Approval of details reserved by condition imposed under LU/287/17/PL relating to Condition Nos 7 - divert public sewer and 8 - foul & surface water sewerage disposal.

46a and 47 Pier Road and Land North of Clifton Road Littlehampton

Arun District Council have decided to **REFUSE details reserved by condition for the following reasons:**

Appendix C
Drainage Layout

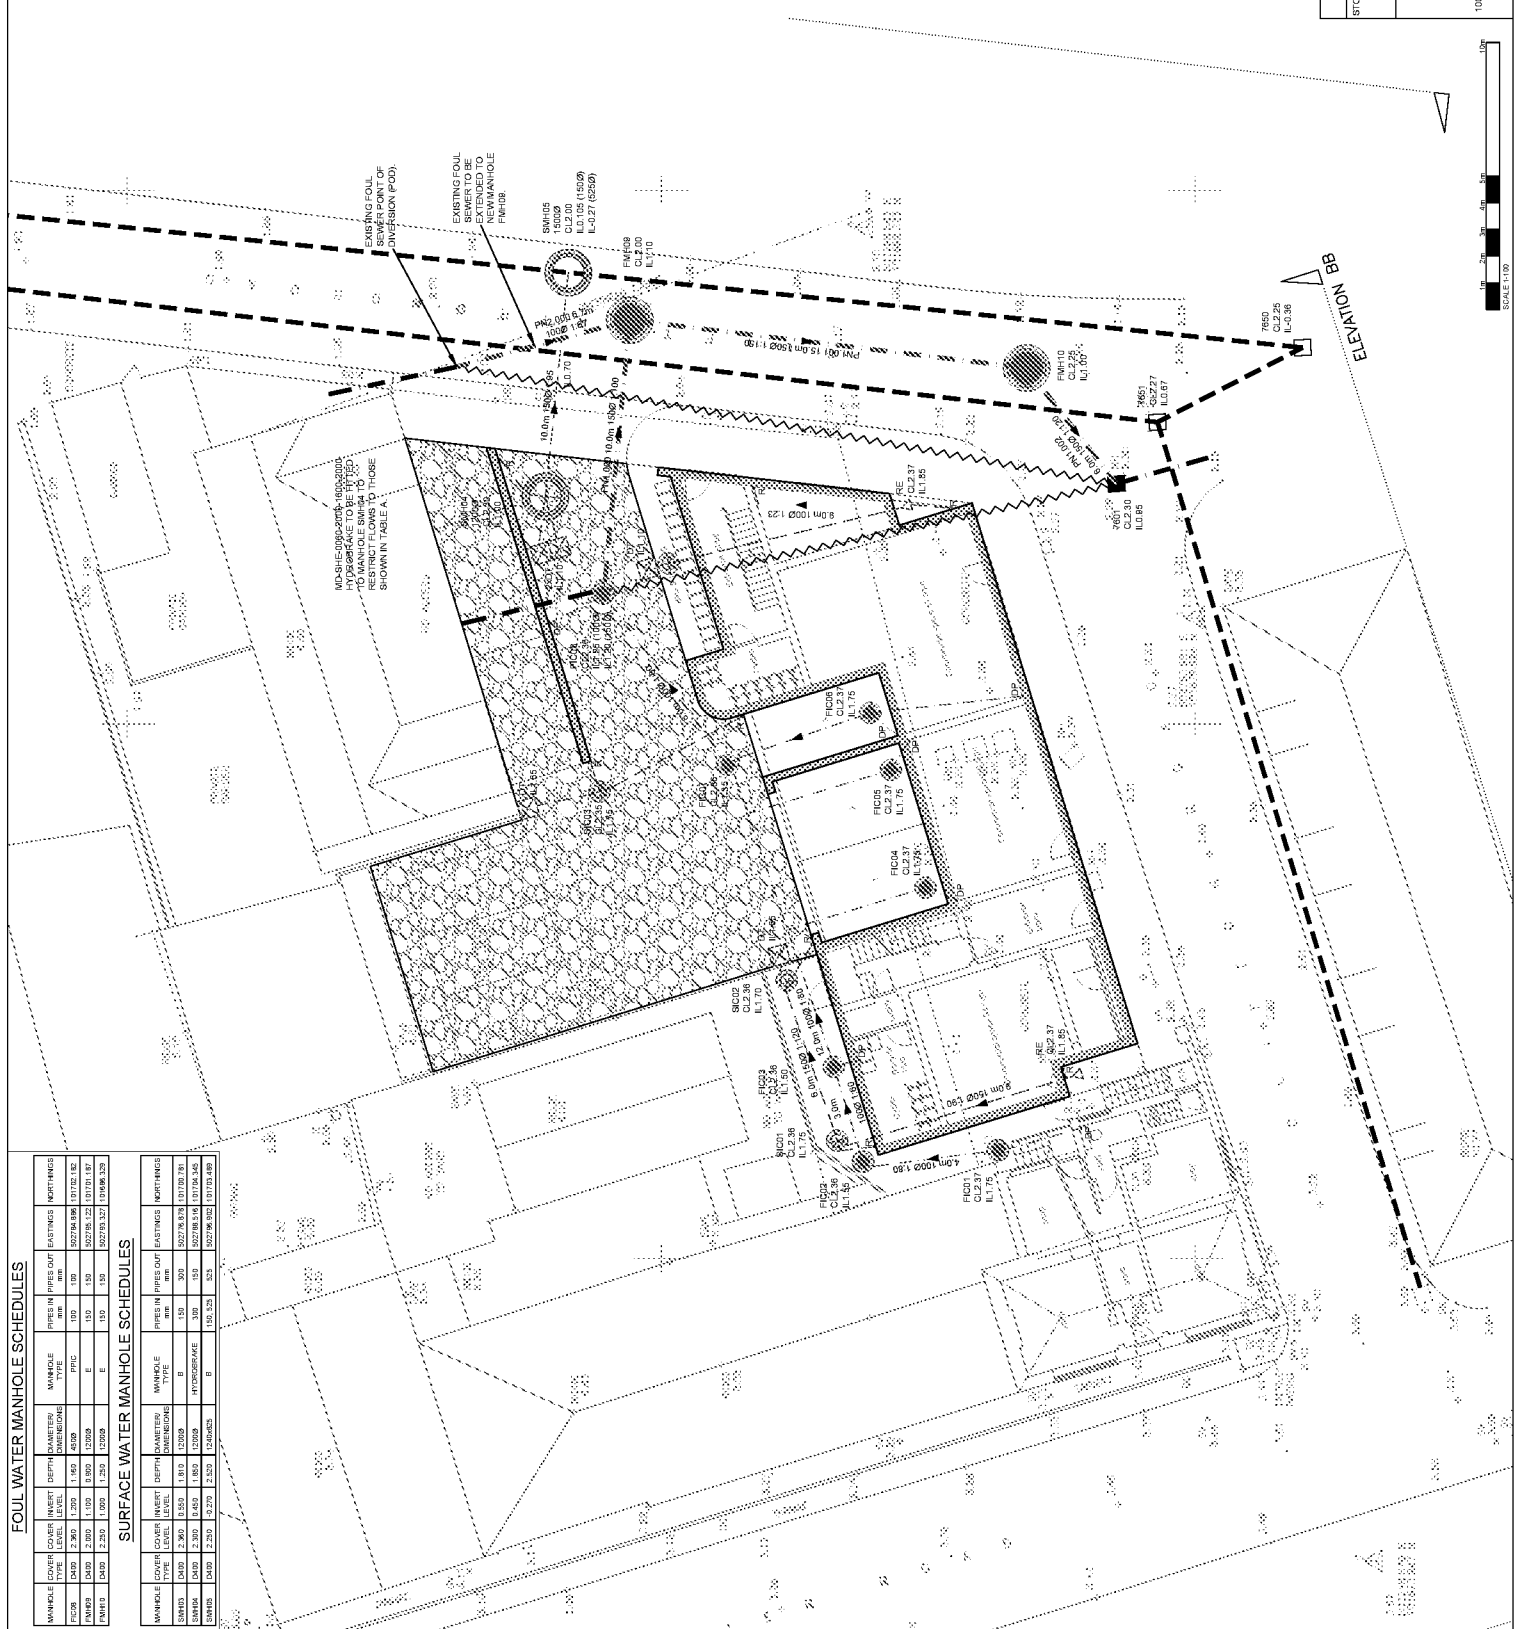
This condition cannot be discharged until any Diversion proposals (reference SWS.S185.002674) have been agreed and approved by Southern Water. The drainage report submitted does not set out measures to divert public sewers.
